Proposed Residential Development, Land East of Chipping Lane, Longridge LCC Transport Assessment Comments on submitted TA by Vectos

These notes are based on the Transport Assessment (TA) and associated documentation submitted by Vectos in relation to the proposed development of 106 dwellings. These notes will follow the layout of the TA and will use the section titles and paragraph numbering from the TA.

Drawing:
Boundary Treatment Plan

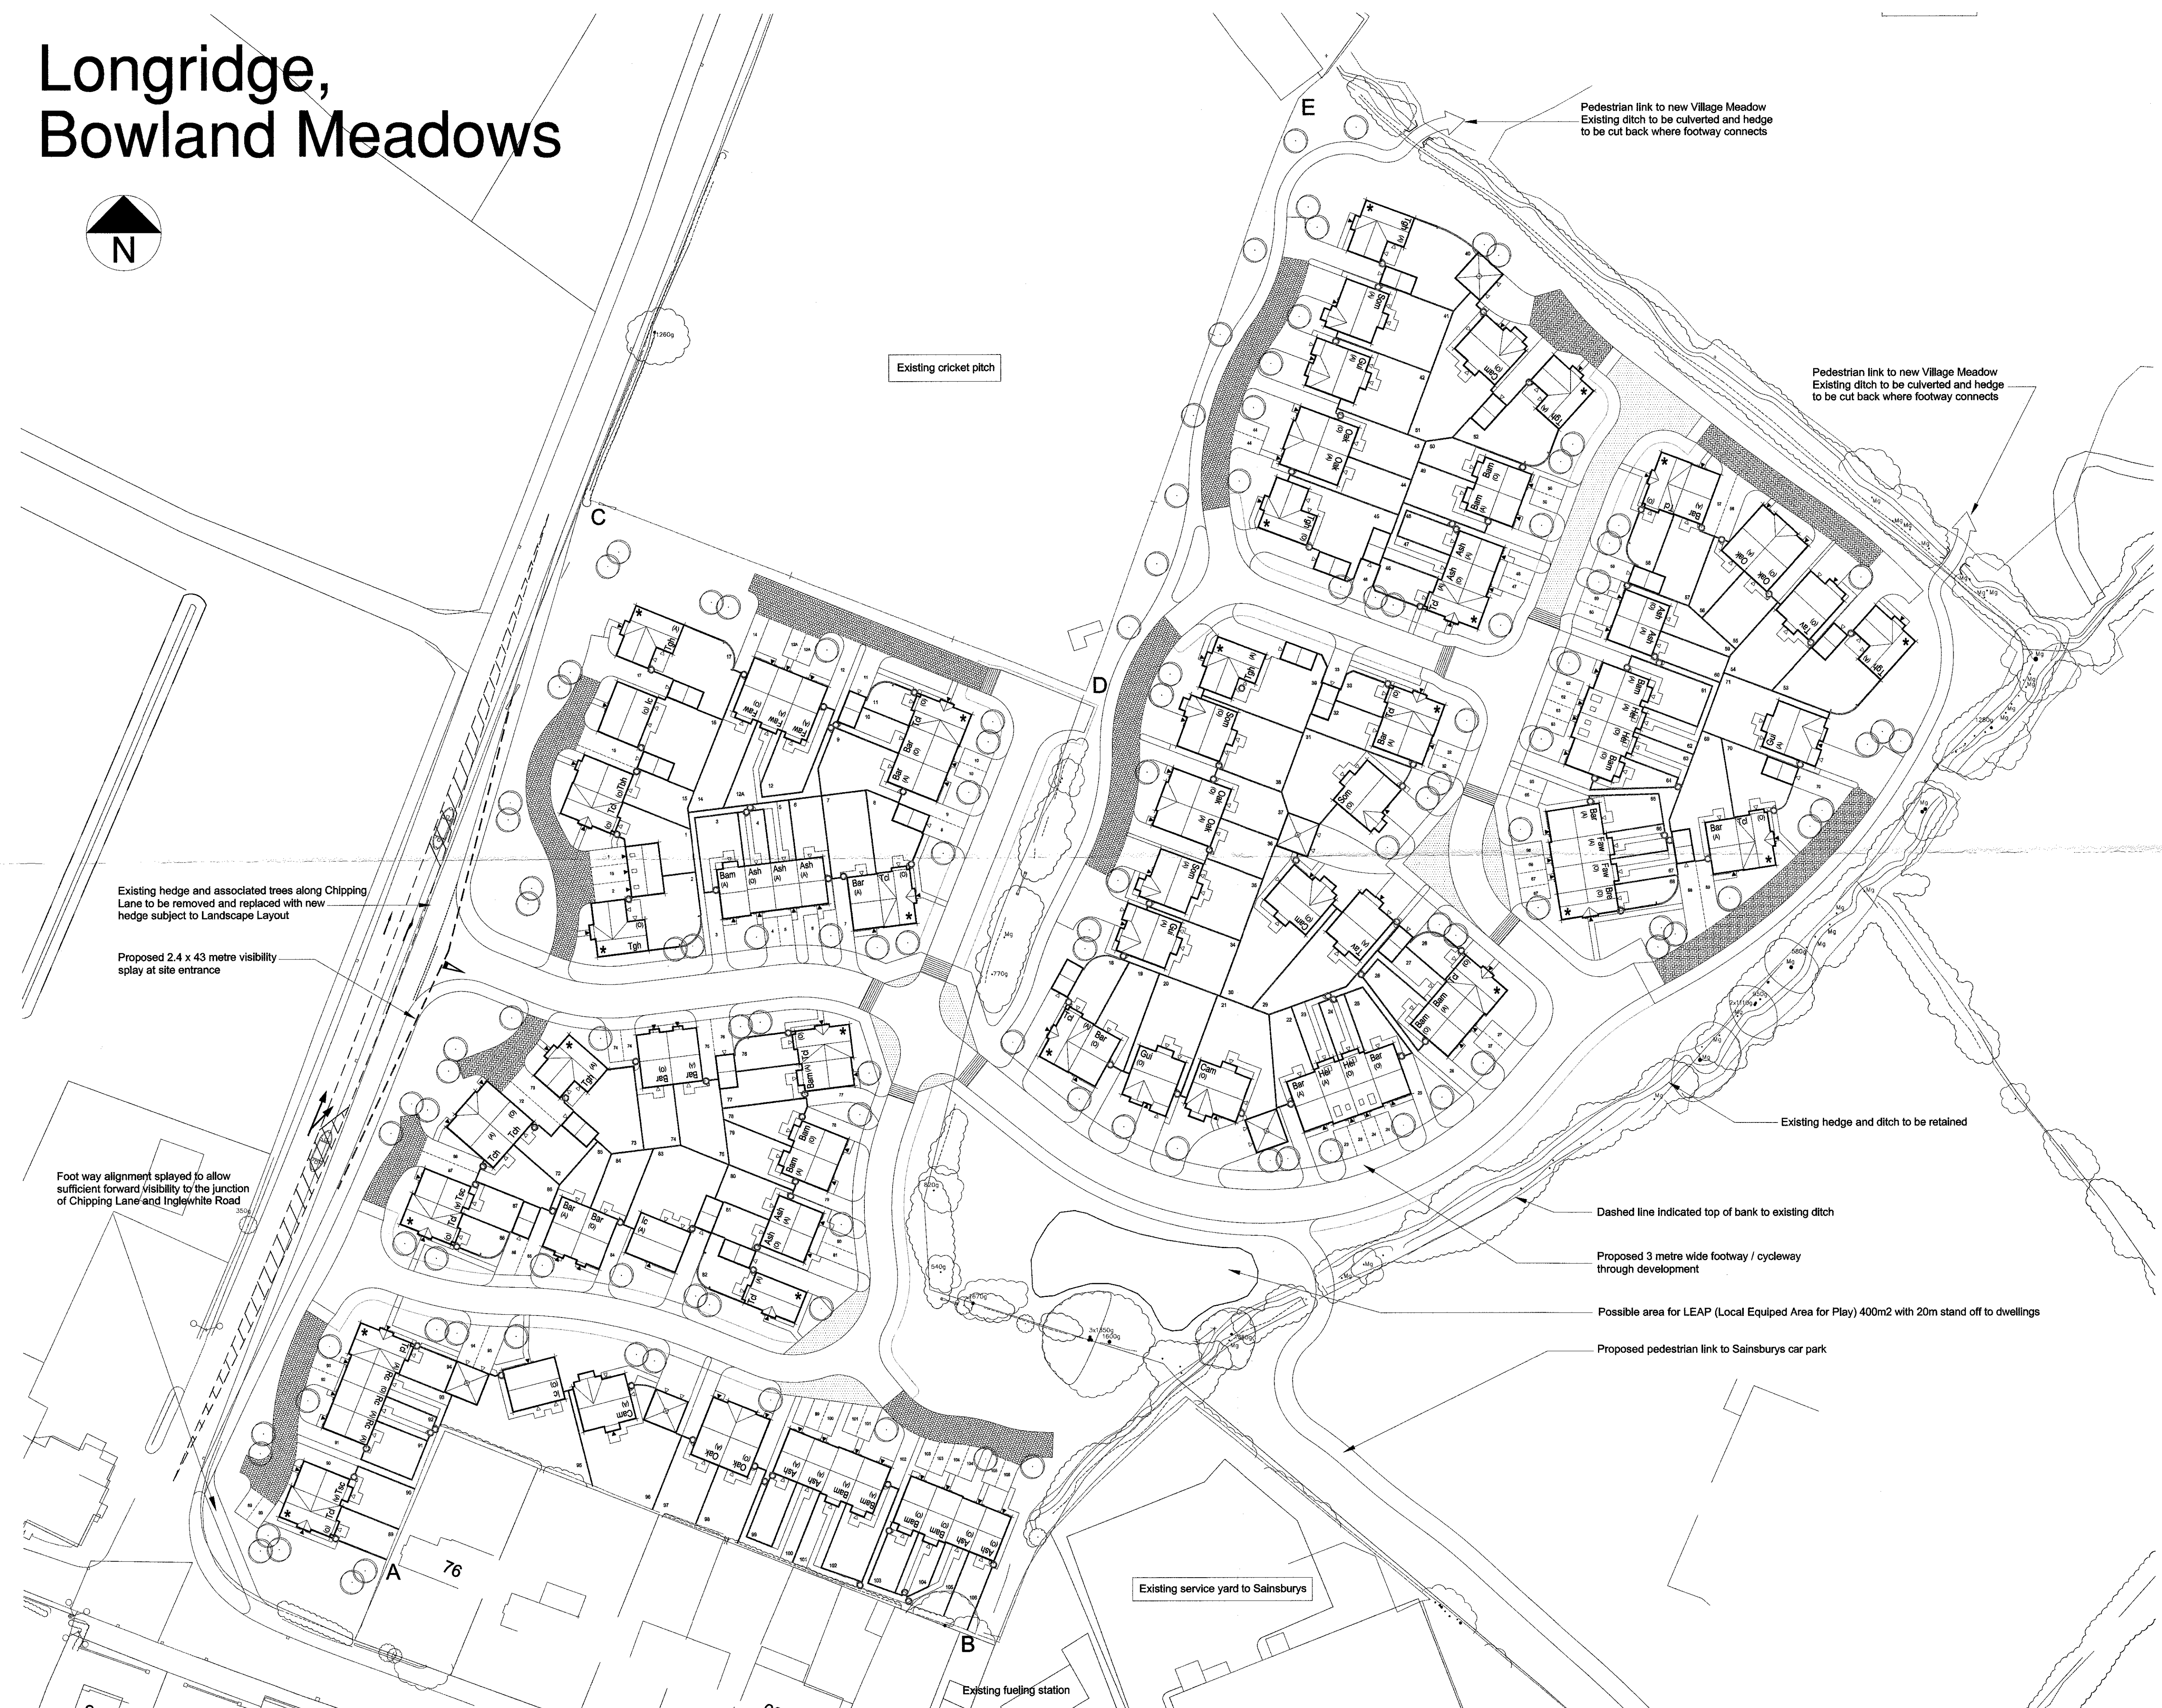
3.1.6 The proposal for a new footway along the site frontage is welcomed however the route must be suitably lit and have a width of at least 3m to cater for joint pedestrian and cyclist use. This will provide a convenient connection from the site to Inglewhite Road, linking into existing pedestrian and cyclist routes. A plan with detail is required.

The TA lacks detail in respect of the pedestrian footpath that is intended to link the site to the Sainsbury's foodstore. Please provide further information specifying width, lighting, surfacing and suitability for mobility impaired users and cyclists. All pedestrian links must be safe, desirable routes. Please confirm whether Sainsbury's has been consulted regarding the point of entry into the car park to ensure that the pedestrian link can be guaranteed.
